Oakdale West Industrial Estate – SSD7348 MOD 6

Response to Submissions

1 February 2021

LOT 1B & 1C, KEMPS CREEK, OAKDALE WEST ESTATE

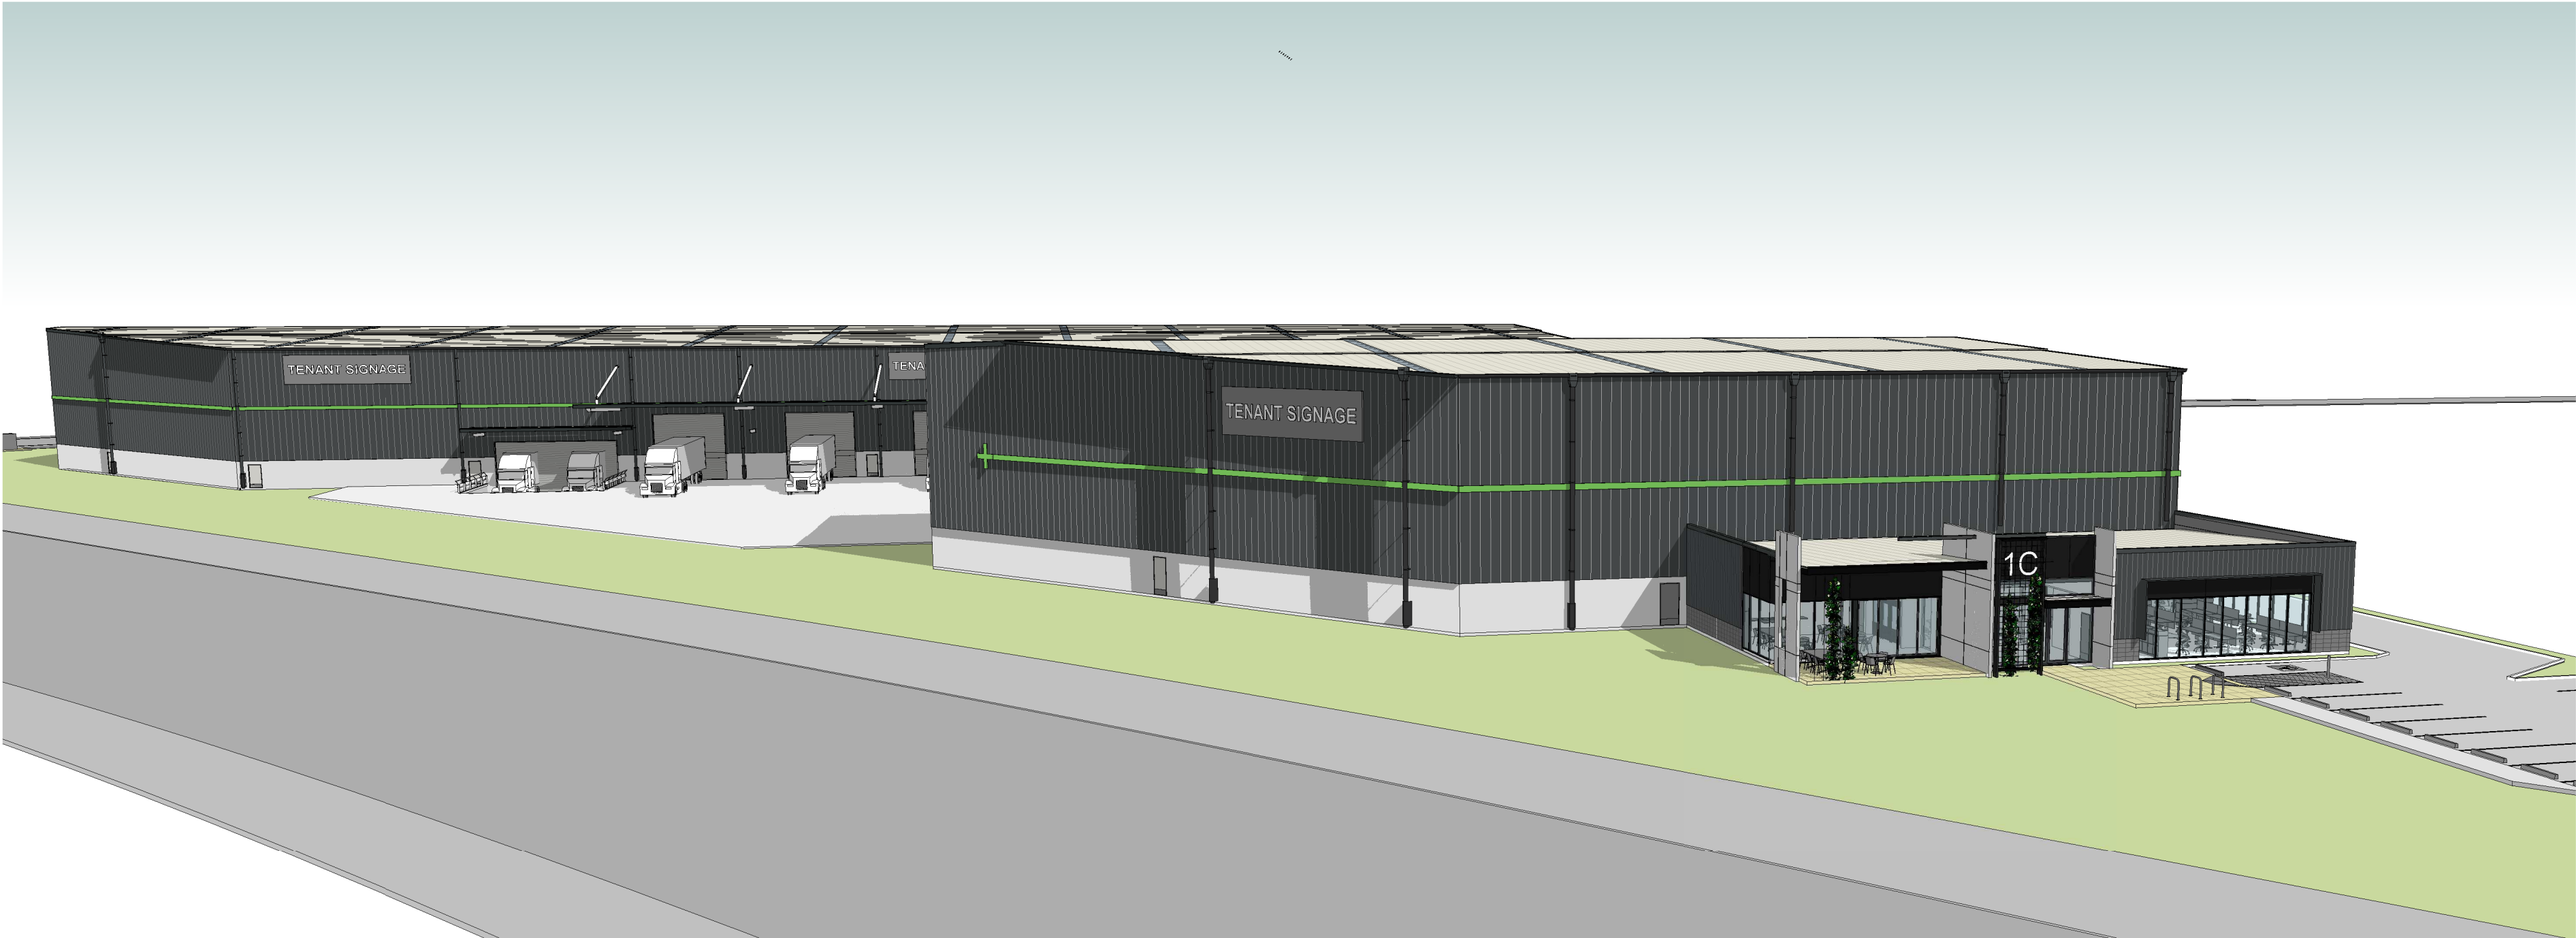
<ul style="list-style-type: none"> - The architectural drawing package makes reference to Stage / Building 1A in the precinct on the Major Projects website however the architectural plans only seem to relate to 1B and 1C. It is requested that it be confirmed no changes are proposed to Building / Stage 1A and its surrounding parking and landscaping design (which is believed to have been approved under Mod 5) and that the Precis for these documents be revised to avoid confusion. 	<ul style="list-style-type: none"> - No changes proposed to the Warehouse 1A in MOD6.
<ul style="list-style-type: none"> - The amended master plan provides a diminished landscape setback for Precinct /Stage 3 when compared to what has been required in Stages 1 and 2. As evident within the approved developments within Stage 1A, B & C, as well as Stage 2B, a 7.5m landscaped setback zone has been insisted upon between the property boundary of the public road network and car parking that is situated forward of the building line. To continue this established character as approved, the spatial arrangement of Warehouse Building 3B and 3C should be amended so that a 7.5m landscape setback is maintained to the western side of the eastern road, to reflect the same landscape character as set up via Stage 2B as approved, and what is proposed for 2A, 2C1 and 2C2 via this amendment. Alternatively, car parking 	<ul style="list-style-type: none"> - As discussed, Council have again misinterpreted the approved DCP setback controls. - The <i>building setback</i> for all internal estate roads are 7.5m, and associated landscape setbacks at 50% of this width, or 3.75m. - The proposed setbacks for Stage 1A, B, C; Stage 2B; and Stage 3B all remain consistent with the approved DCP building and landscape setback controls. - To ensure consistency throughout the precinct, uniform setbacks are included in the architecture plans.

Site Boundary	
Building 17.15m Setback to Main Road	
Landscape 7.15m Setback to Main Road	
Building 7.5m Setback	
Landscape 3.75m Setback	
Chainwire Fencing	
Palisade Fencing	
Retaining Wall

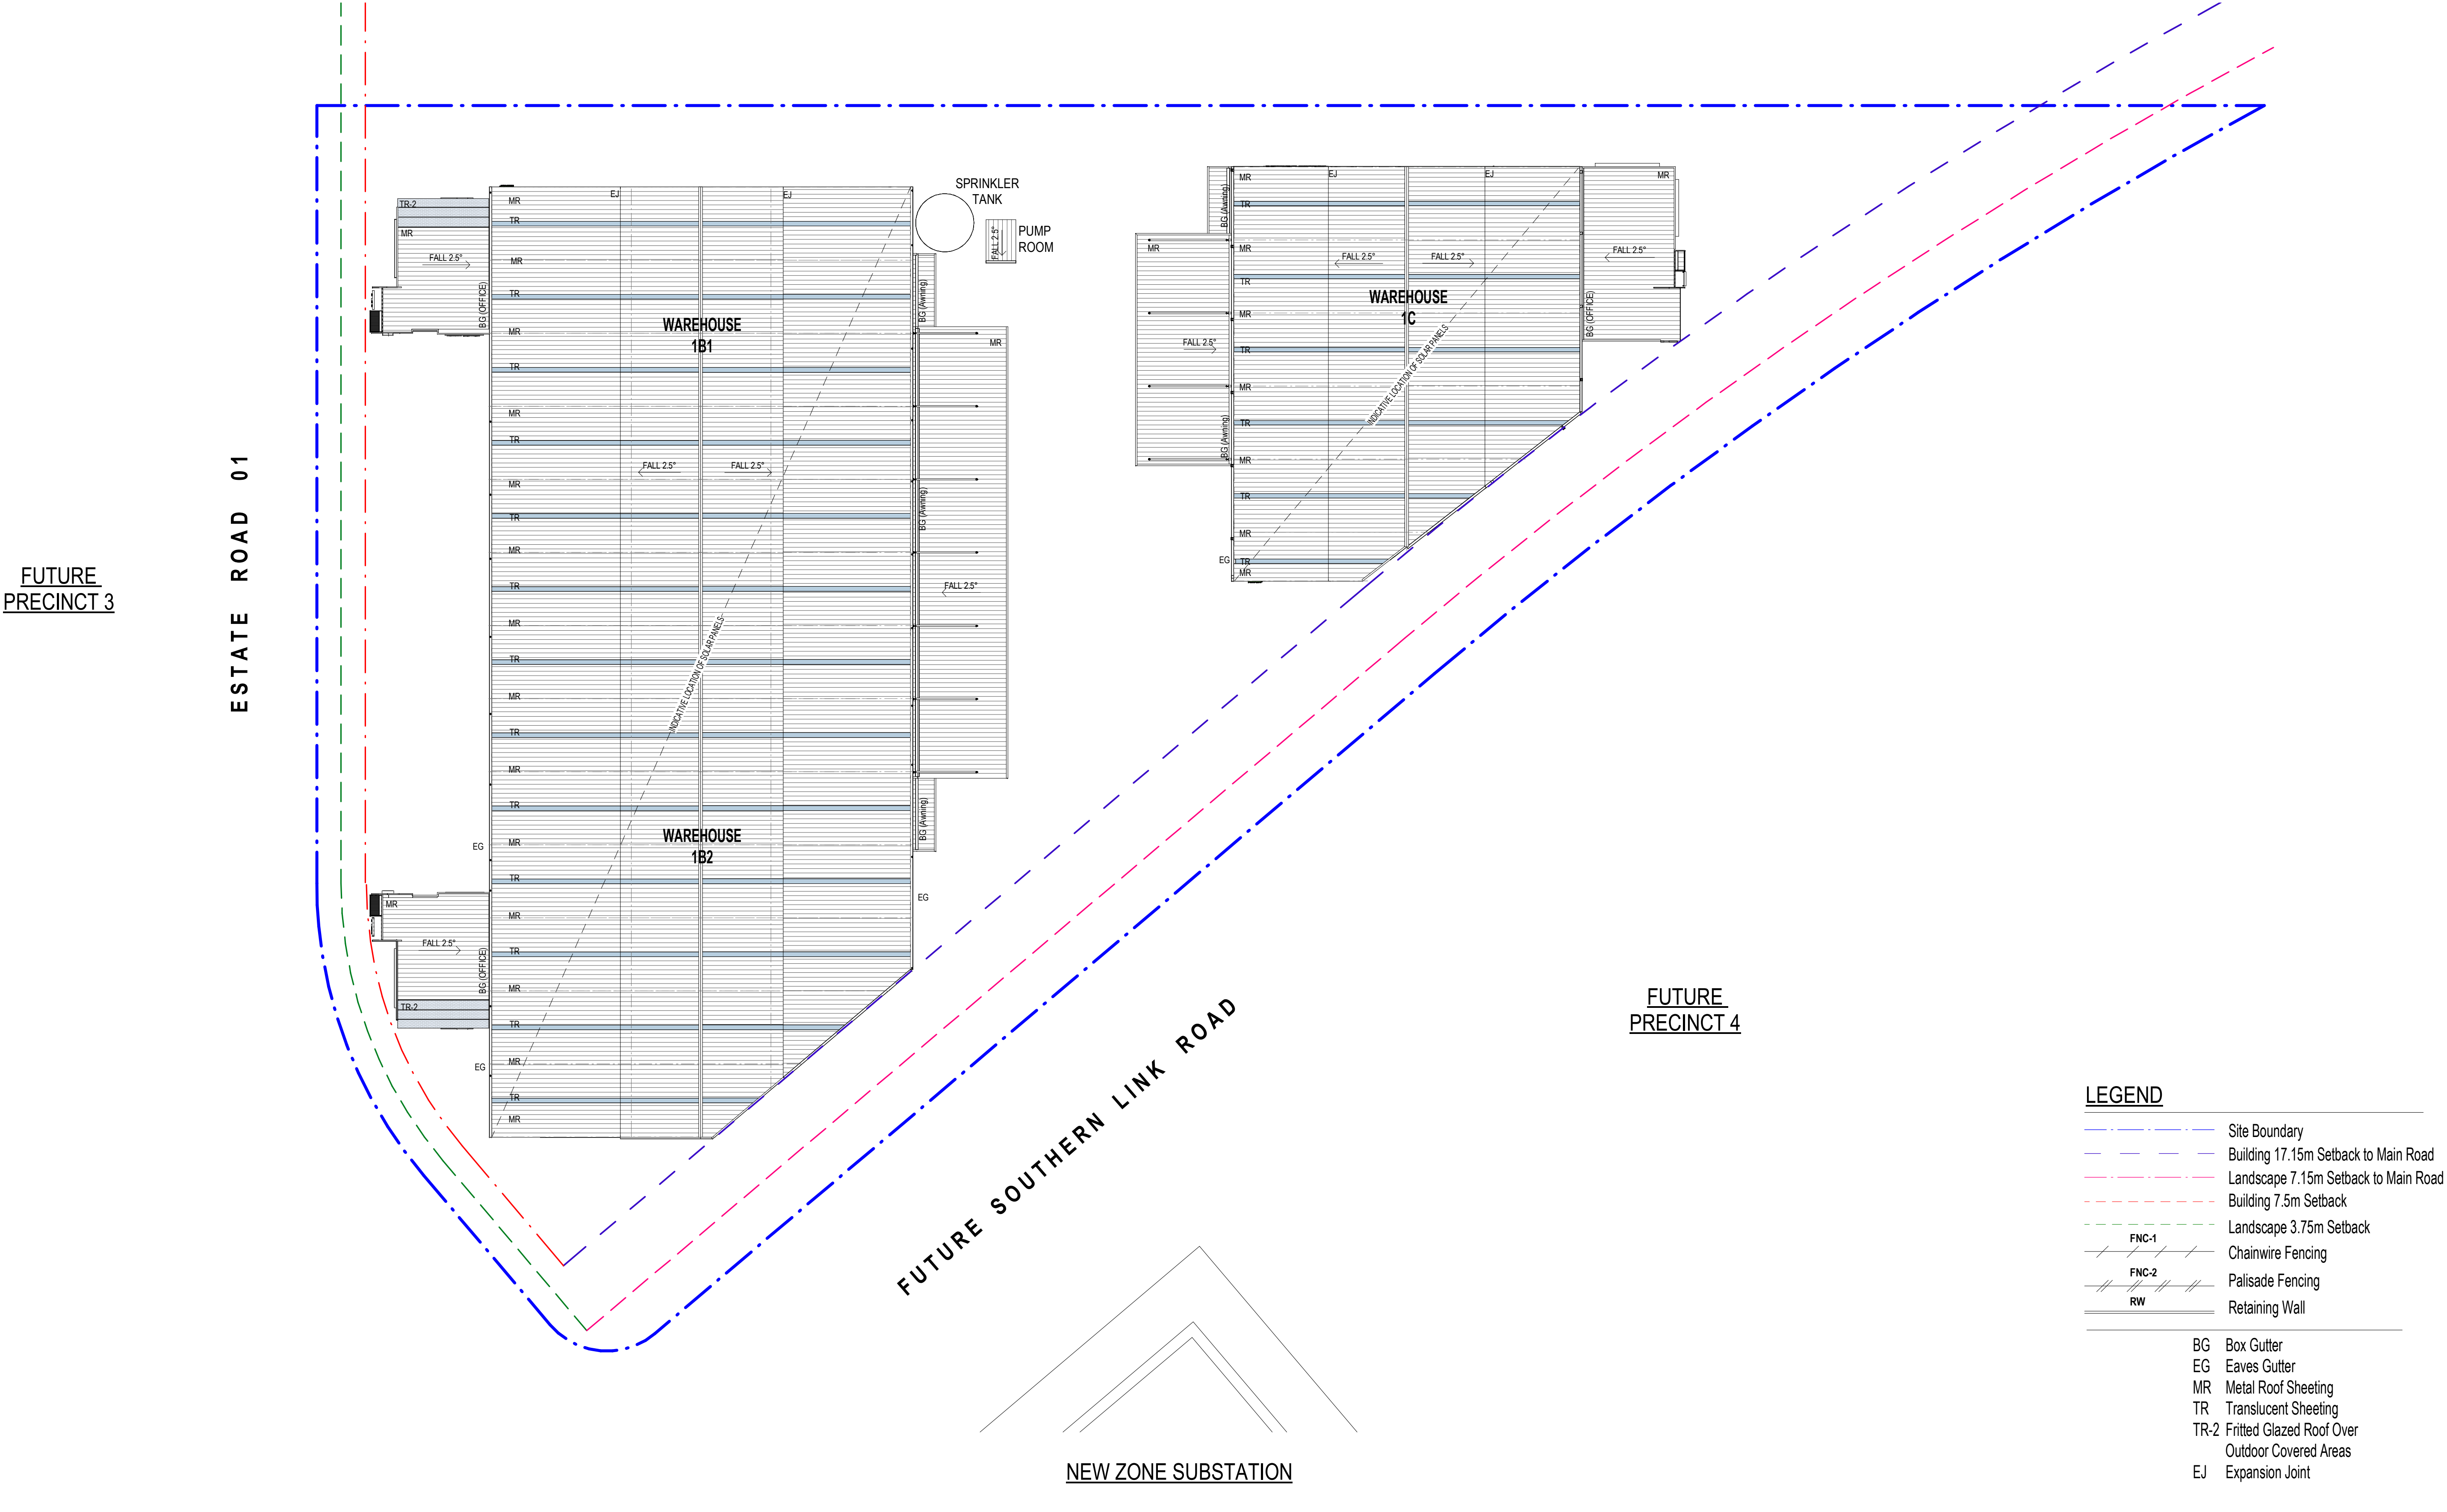
Matters Raised	Applicant Response
<ul style="list-style-type: none"> - Warehouse 1B1 – The indication of bike parking on the above paved area is also unsupportable and should be removed and relocated within the site and not in a location that erodes necessary setback planting between the car park and property boundary. 	<ul style="list-style-type: none"> - The bike parking is not located within landscape setback.
<ul style="list-style-type: none"> - Warehouse 1B2: Same issues as above with Warehouse 1B1 with respect to paving in required landscape setback zone and relocation of indicated bike parking 	<ul style="list-style-type: none"> - Setback response as above. - The bicycle parking has been relocated from the pedestrian path to be located outside of the <i>landscape setback</i> (see Attachment A). - The width of the pedestrian path connecting the 1B2 office to the road has been reduced to limit impact on landscaping, but still comply with BCA access requirements.
